WELWYN HATFIELD BOROUGH COUNCIL – DEVELOPMENT MANAGEMENT
DELEGATED REPORT

APPLICATION No: S6/2015/0956/FP

SITE ADDRESS: St Audreys Retirement Home 15 Church Street Hatfield

DESCRIPTION OF DEVELOPMENT: Installation of flat roof with 2no roof lights over existing conservatory following the removal of existing roof

PROPOSED PART ROOF PLAN

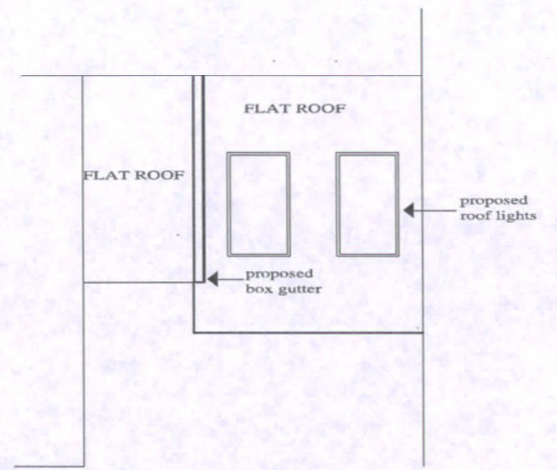
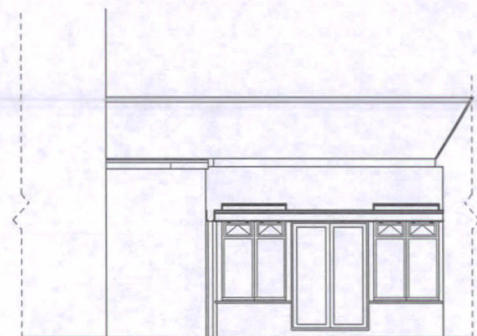
The material for the roofing should be conditioned as lead, or stainless steel coated in zinc or terne. The roof lights could then be slim metal conservation types which are not bulky and ugly like the standard flat roof lights

A consultation response has been received from the Welwyn Hatfield Borough Council Conservation Area Officer. Upon observation of the building, the officer has recommended that the material of the flat roof should be conditioned as lead, or stainless steel coated in zinc or terne giving way to slim metal conservation type roof lights which are not bulky and ugly like the standard flat roof lights. The applicant has responded to this consultation response accepting the proposed materials.
